Jamey,

The proposal is missing significant information related to traffic & safety, and some of the information provided is either inaccurate or misleading. Note that I've added comments in red to the Vicinity Map and attached it here so it's easier to understand my comments.

FS Rd 4517:

FOWLER CREEK GUEST RANCH
EXHIBIT 12
EMERGENCY INGRESS AND EGRESS PLAN

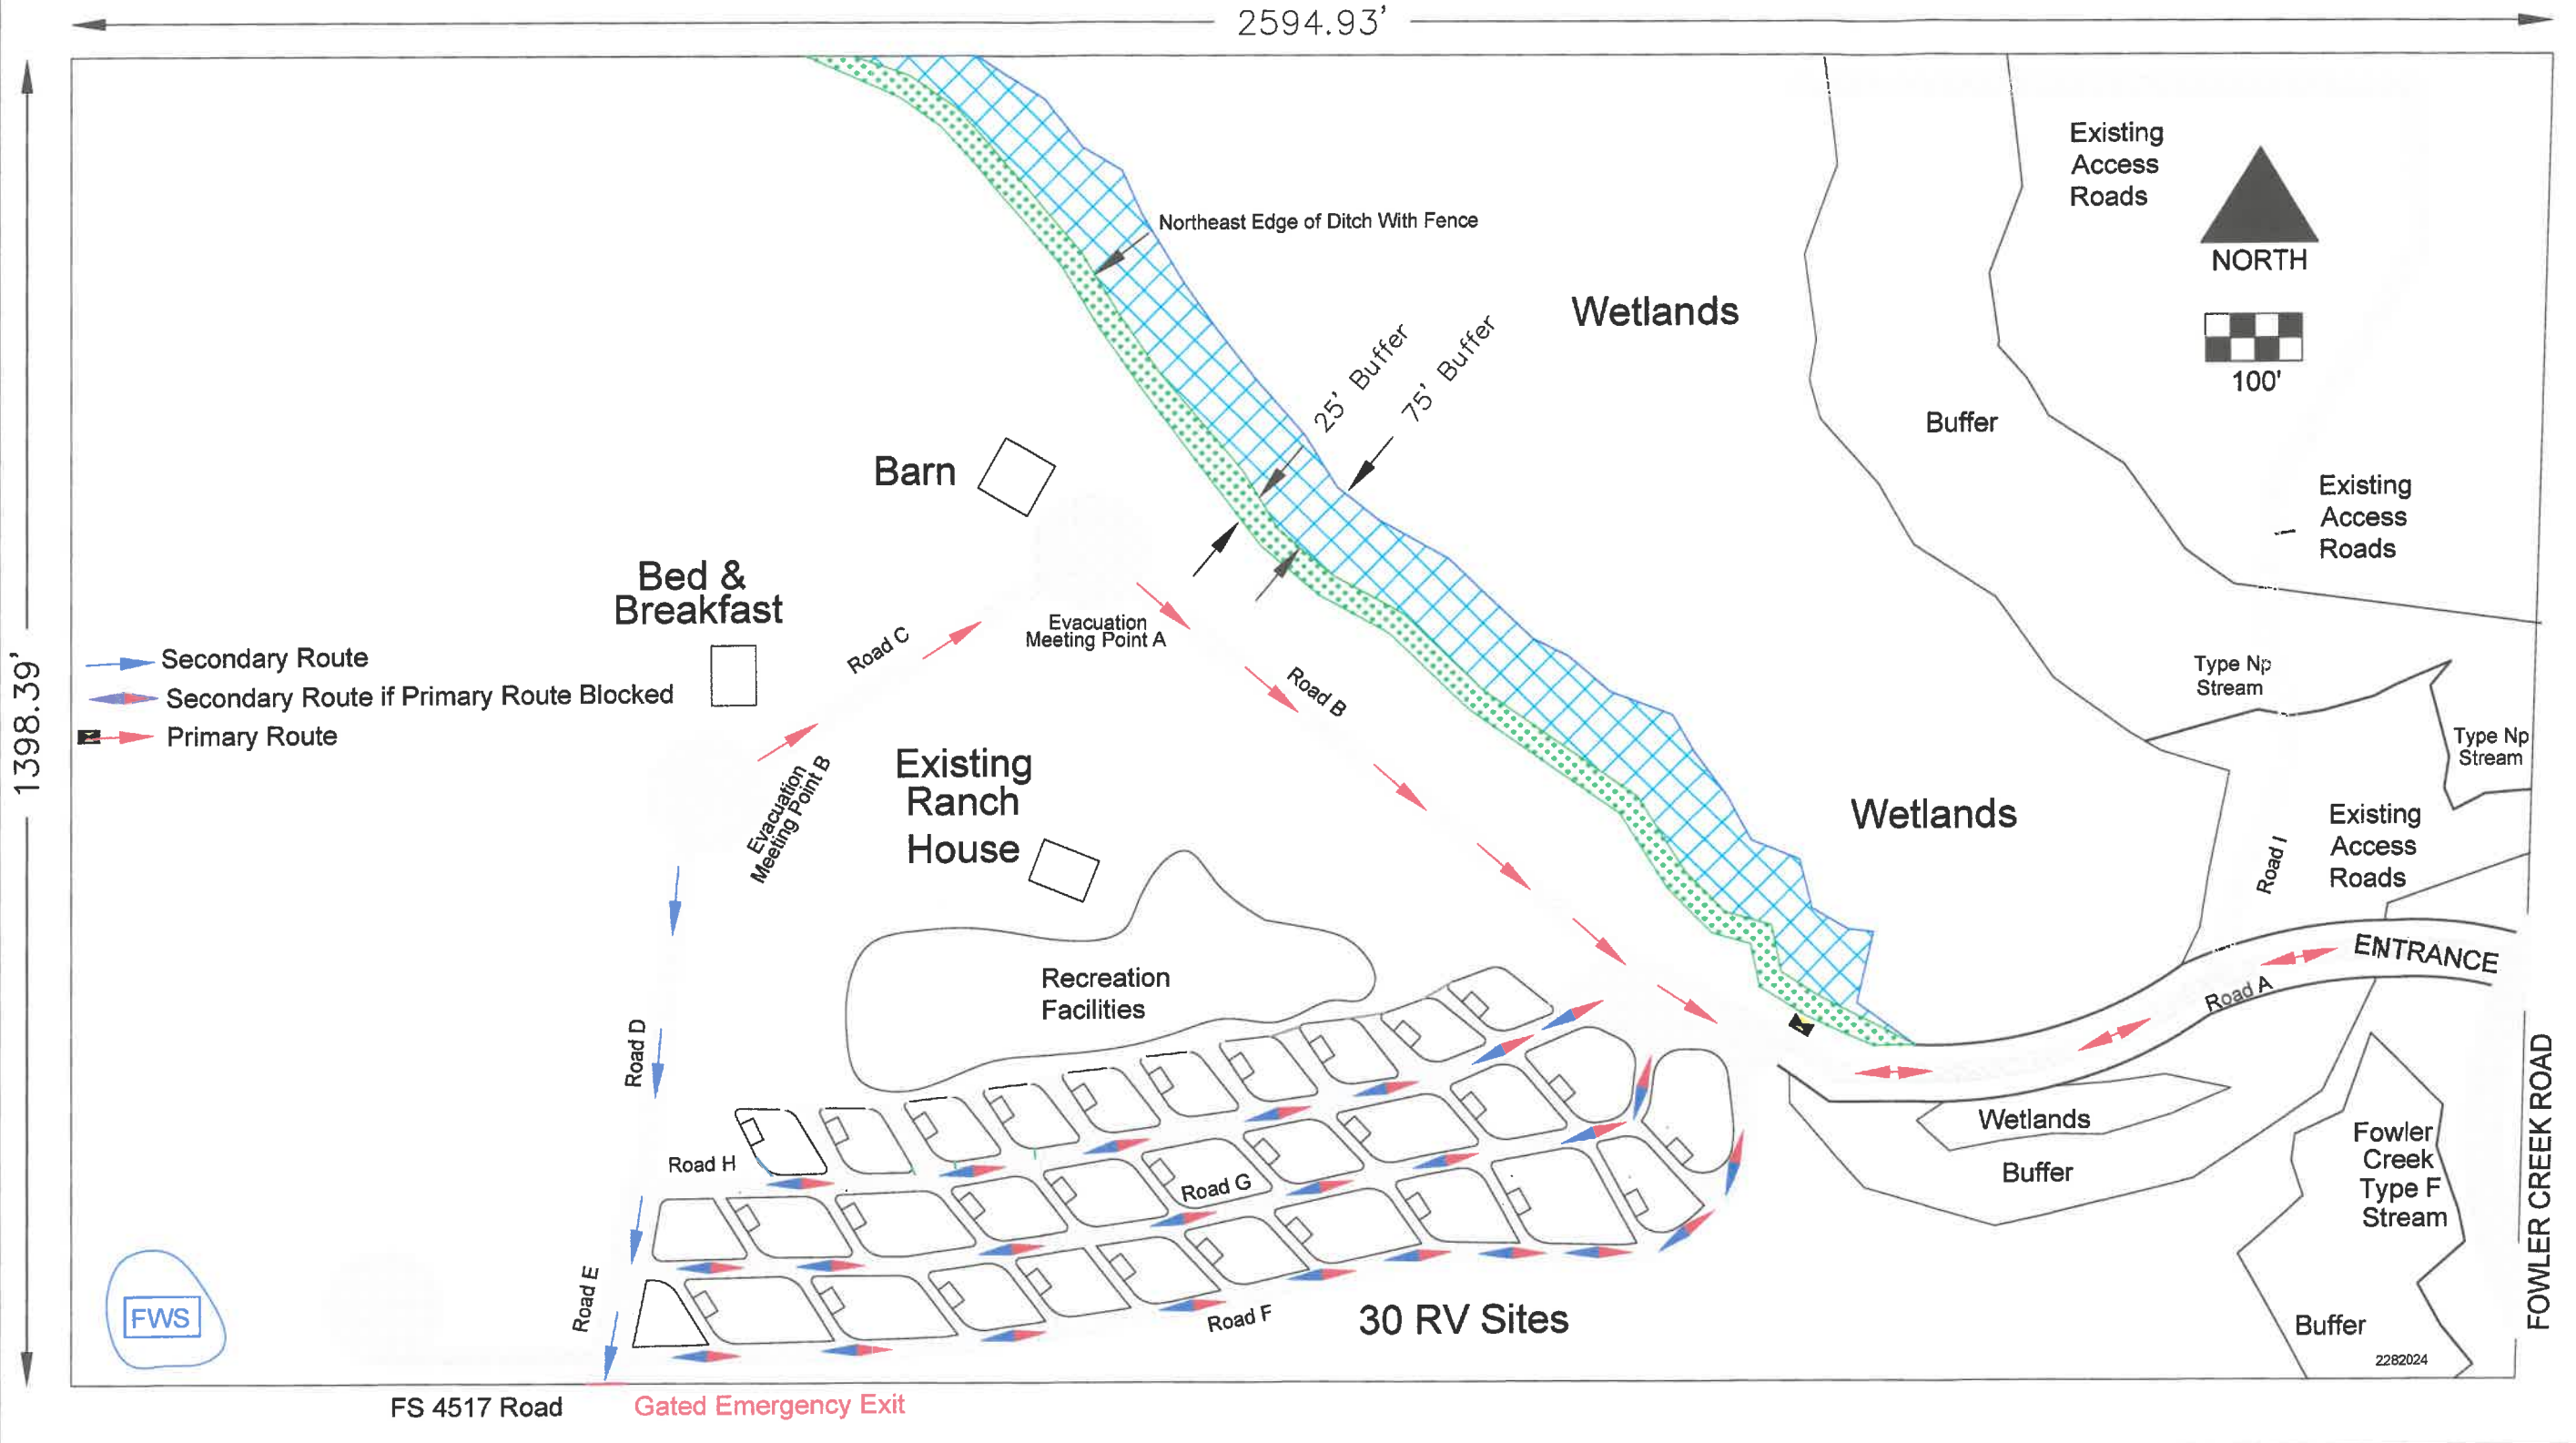
Exhibit 12 Traffic – This plan barely mentions 4517 and all the vehicles exiting from the site onto this dangerous road. The map in this section doesn't even show FS Rd 4517 on it. They list traffic counts, but not for 4517.
